ASSESSMENT REPORT

Section 75W Modification Mixed Use Development (MP09_0121 MOD 1) Ettalong Beach

1 LEVEL 4 FLOOR PLAN
1 : 200

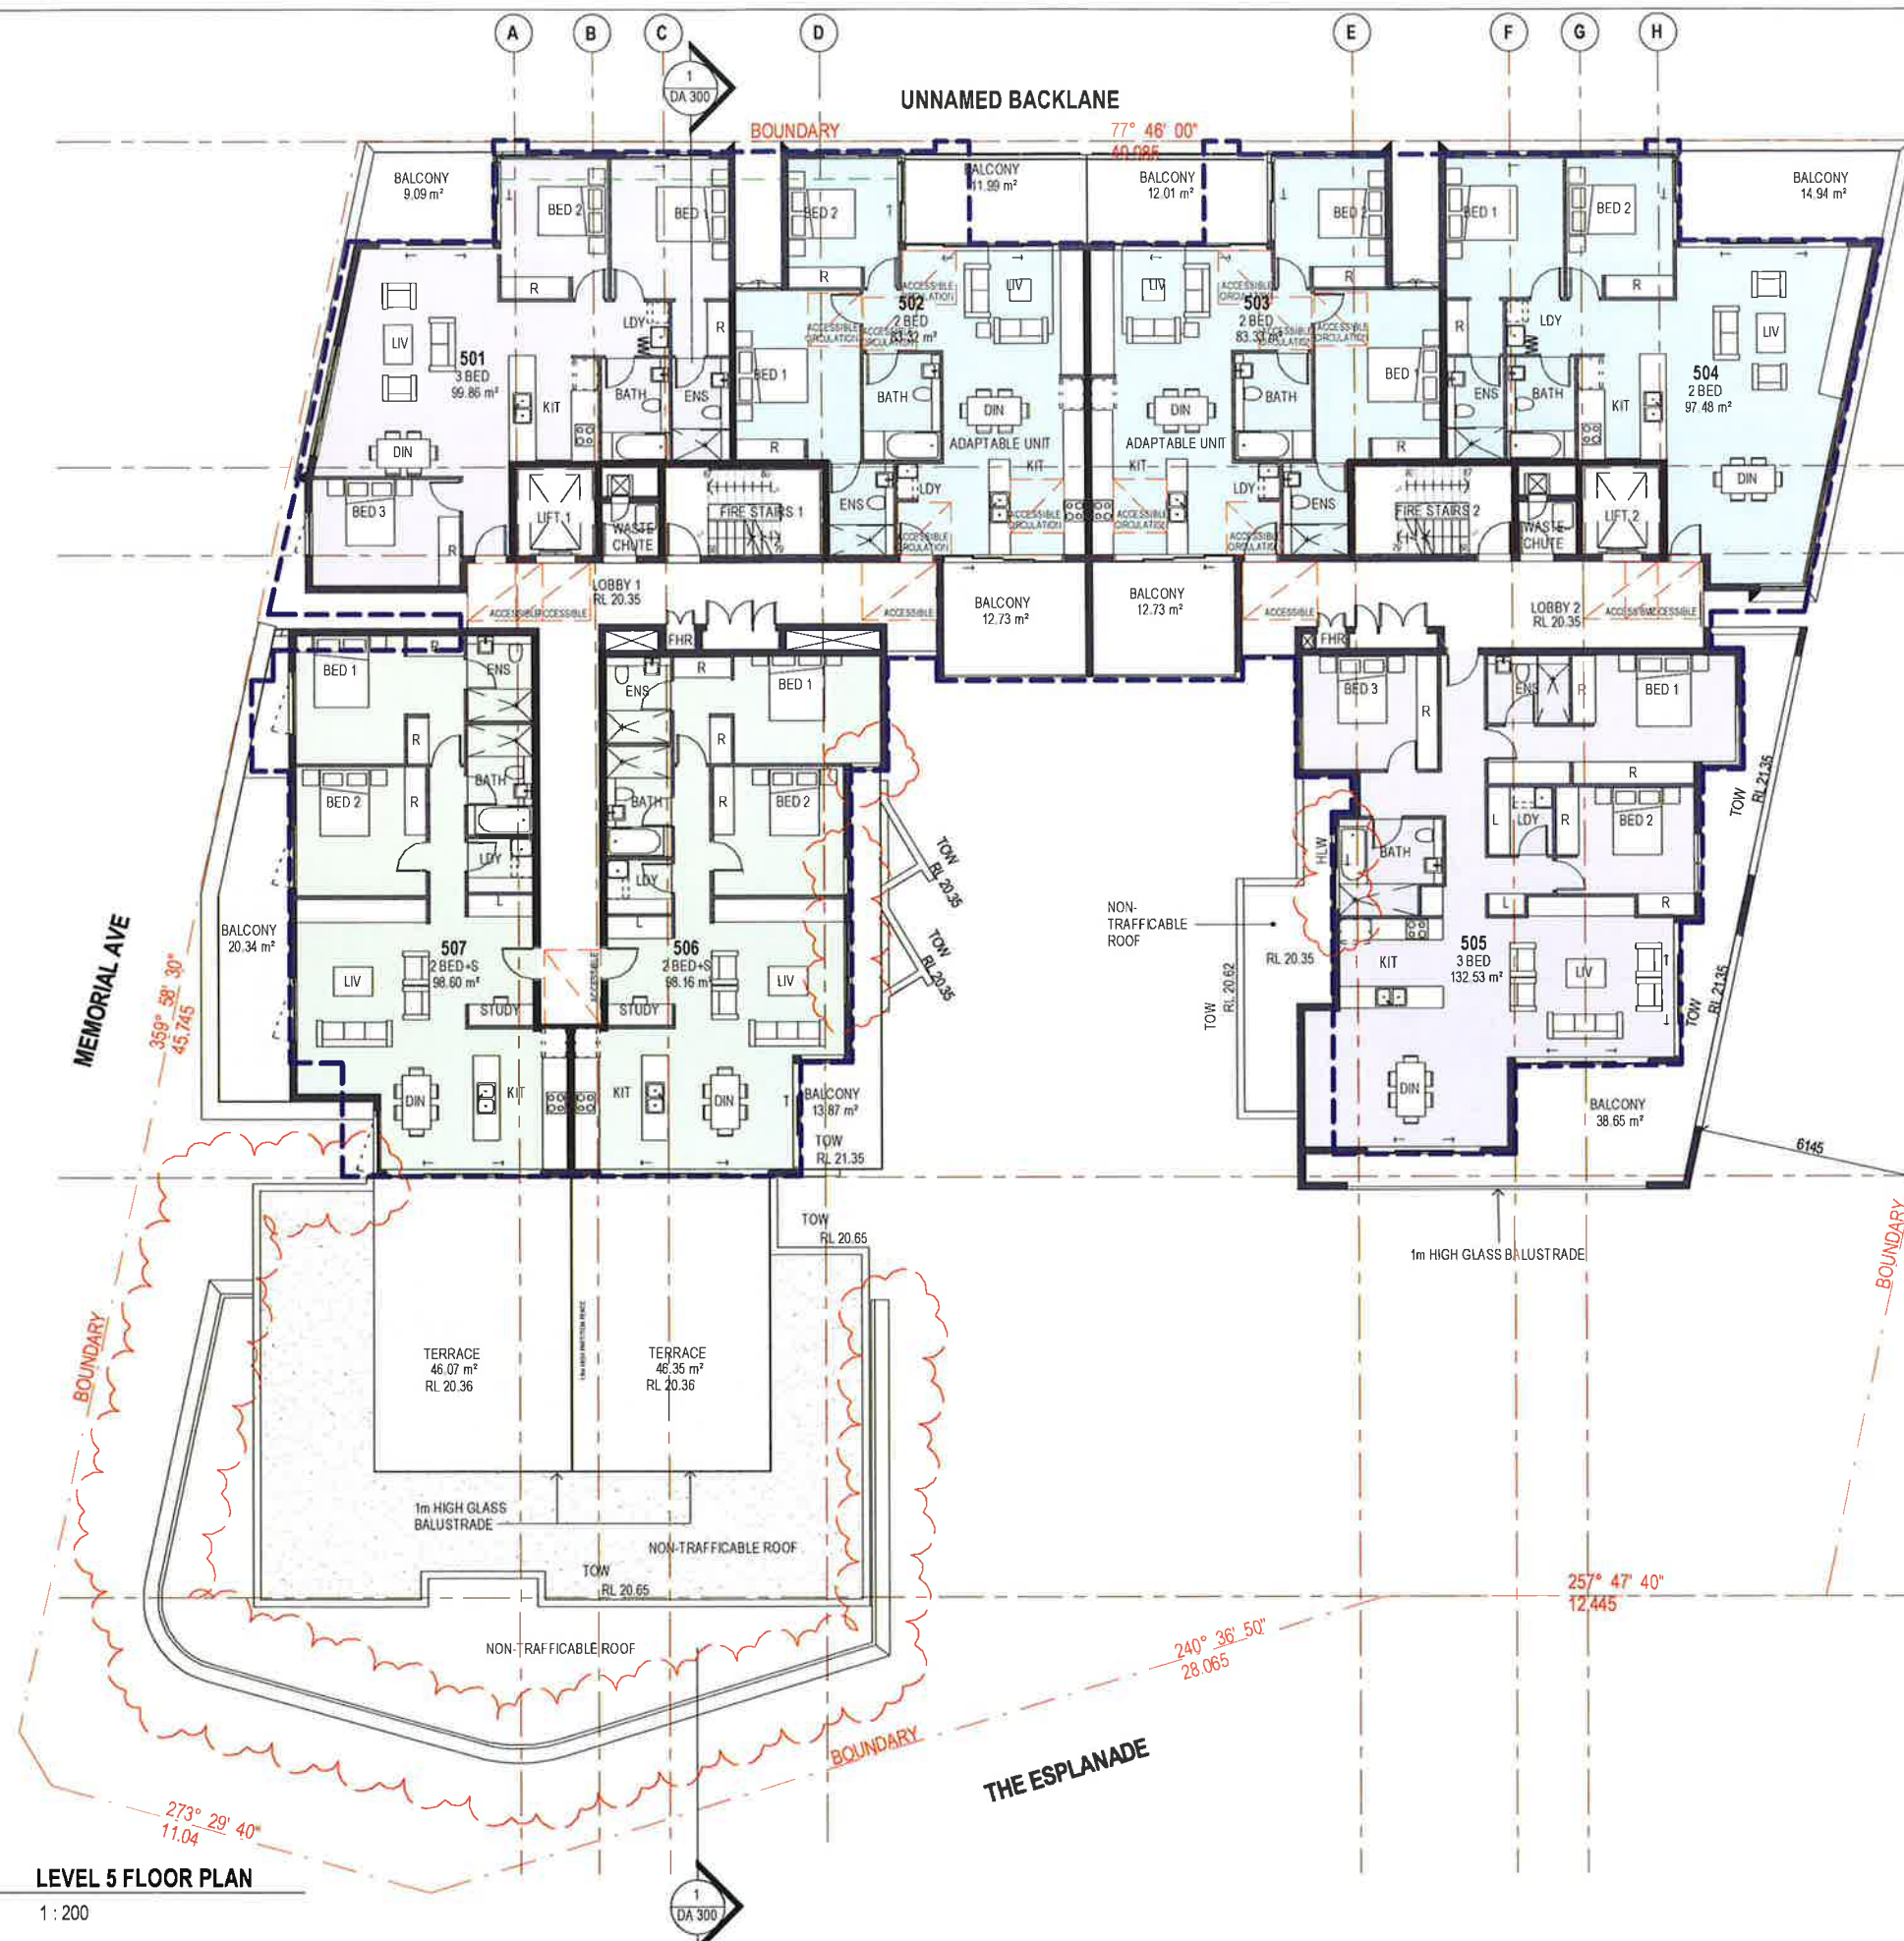
The proposed modification includes a reduction in the internal separation between the eastern and western wings of the development at levels 1 to 4 by up to 3 metres. Internal building separation at these levels would be between 9 metres (level 4) and 11.5 metres (levels 1 to 3).

- tree planting at level 1 would provide landscape screening between the lower level units;
- lower level units are oriented with their primary living areas and balconies to the outer face of the building and incorporate only highlight windows to the bedrooms adjacent to the internal courtyard; and
- upper level units have also been designed to minimise overlooking, orienting living areas and balconies to the south and south-west and otherwise incorporating only highlight windows to the other rooms on the internal facades.

1 LEVEL 5 FLOOR PLAN
1:200

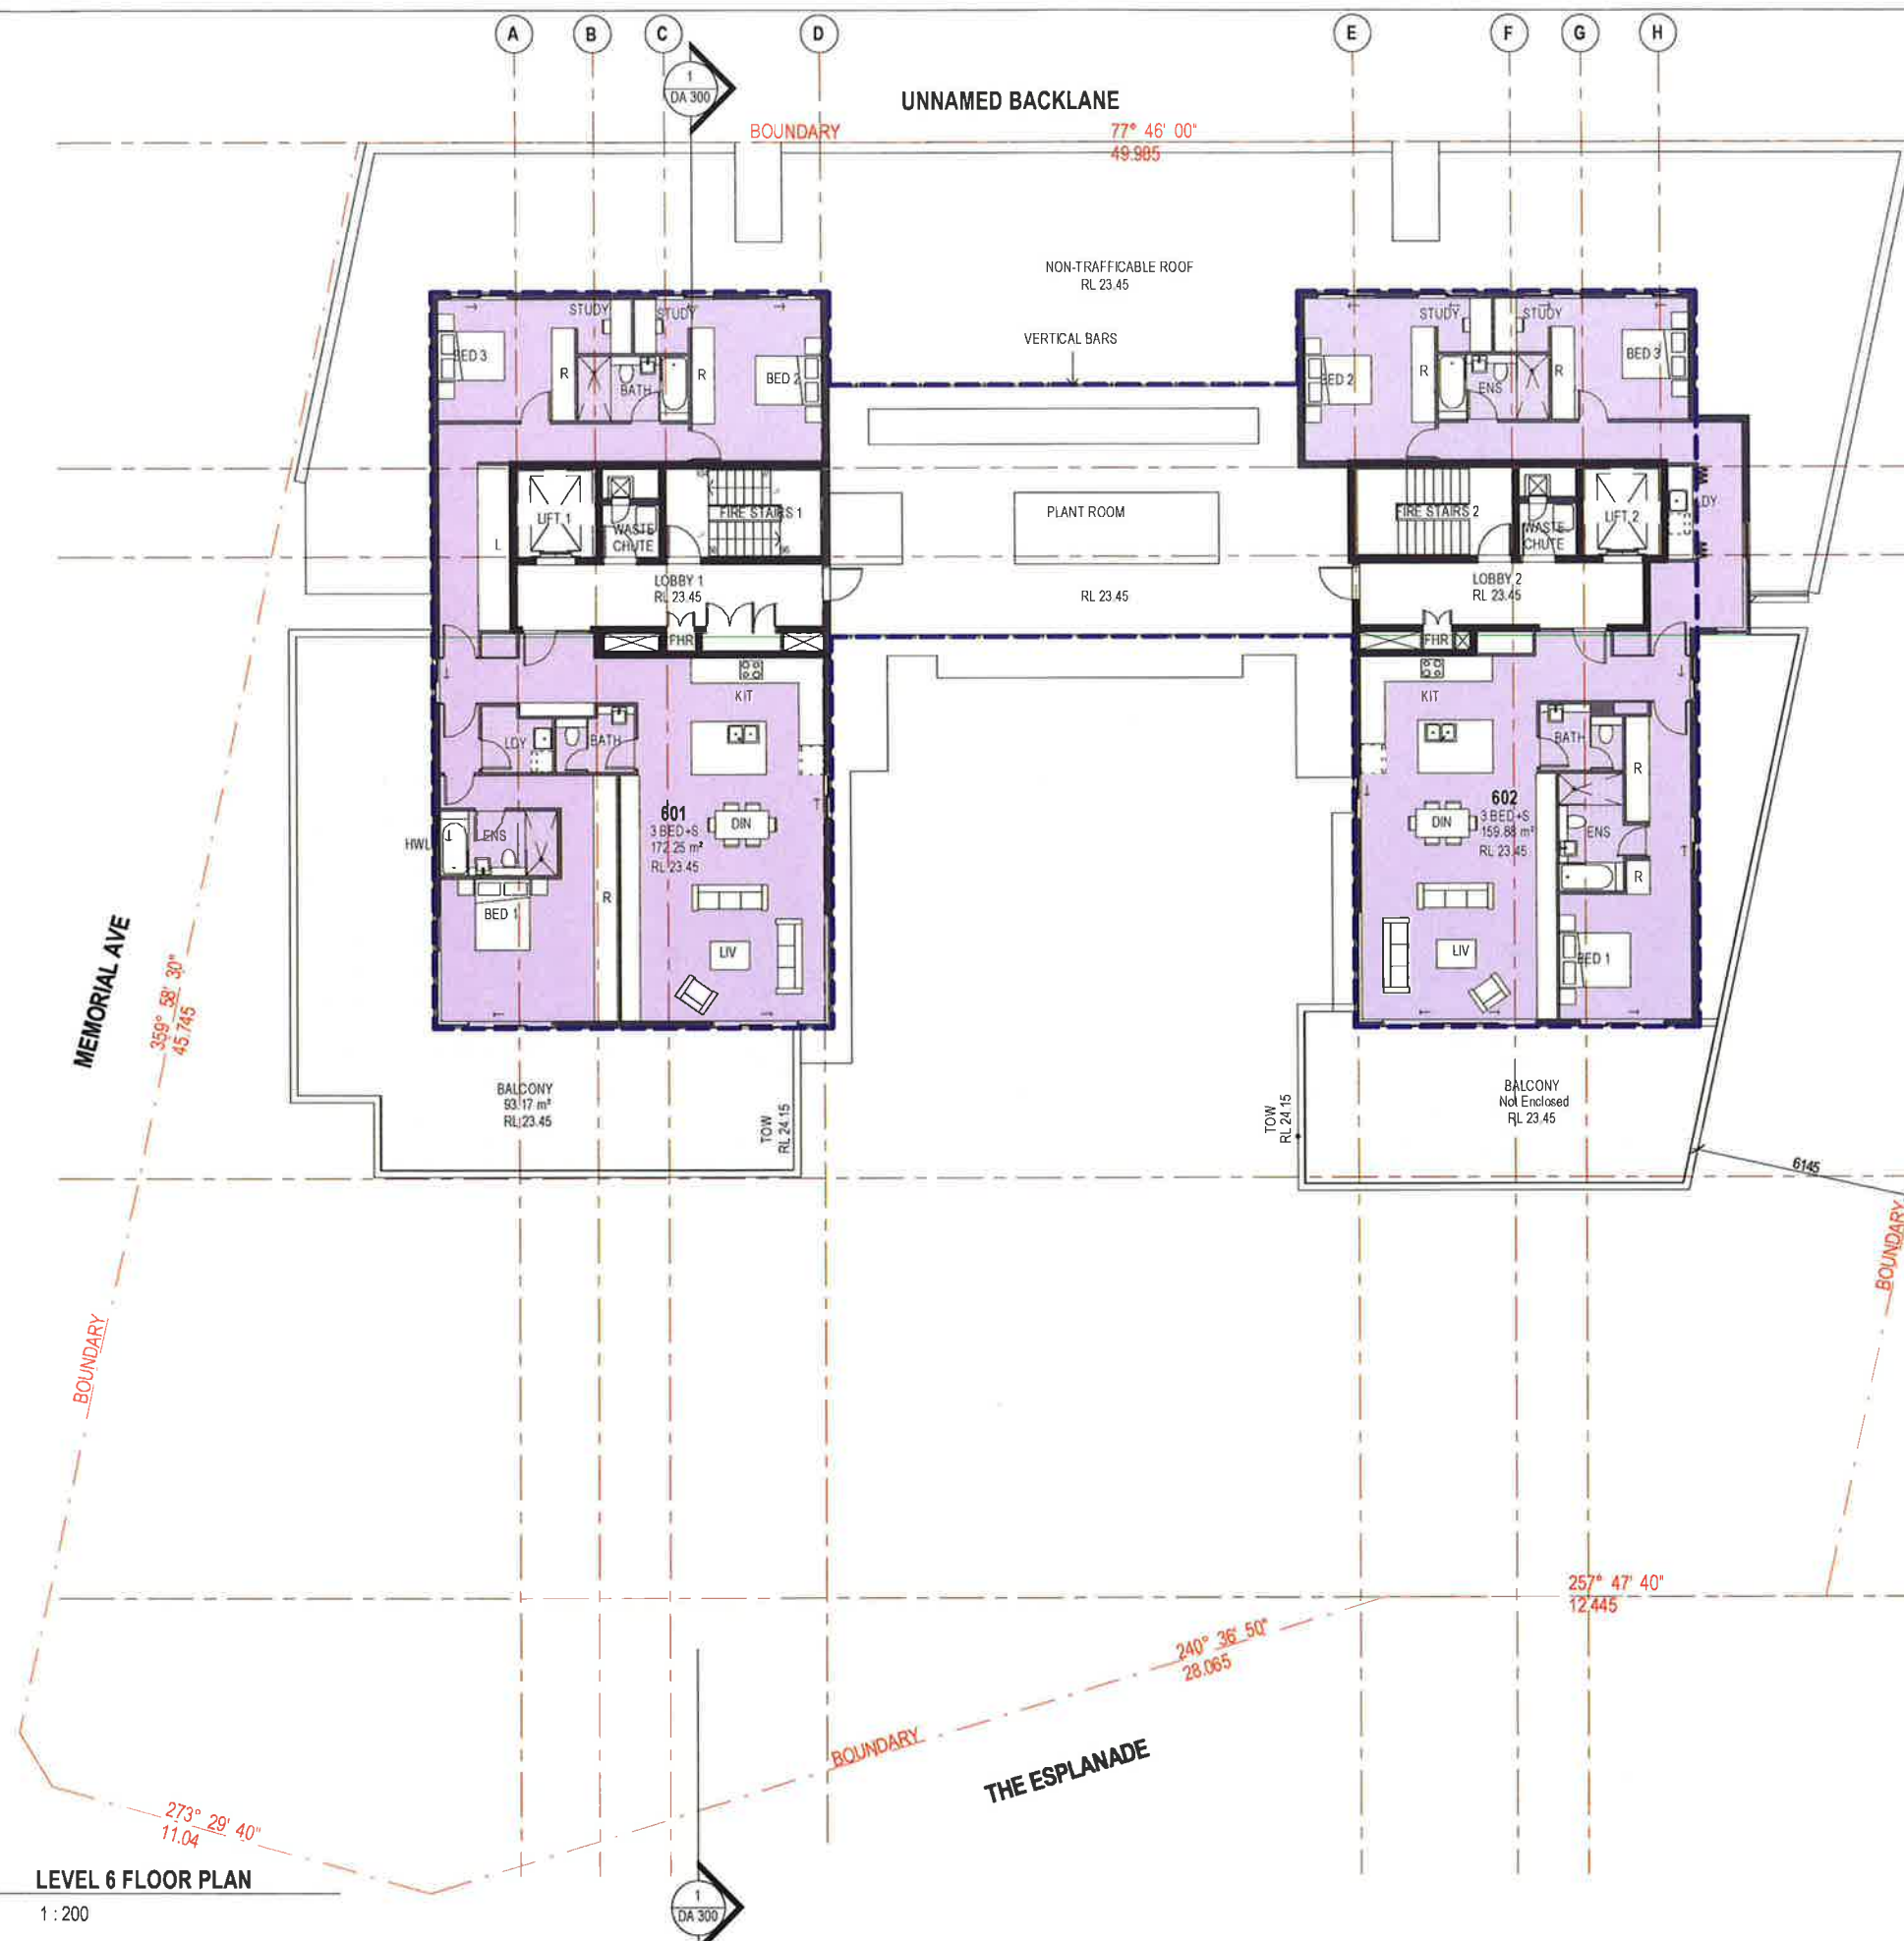
Of the 59 proposed units, only one balcony does not meet the minimum size recommendations of the ADG. The three bedroom unit at the north-west corner of Level 5 has a balcony size of 9m², but is otherwise identical in design to the other units at this location on the other floors, which have balconies of 12.6m². The Department considers that it would be reasonable for the fifth floor unit to adopt the same floorplate as the units below, providing a balcony of 12.6m² which would meet the ADG requirements and provide a better level of utility and amenity to serve the needs of a three bedroom unit. With an internal floor area in excess of 98m², the unit would still retain a generous internal area, despite the increased balcony size. A condition is therefore recommended requiring the size of the balcony to be increased. Subject to this modification, the proposal would provide generous levels of private open space for all units.
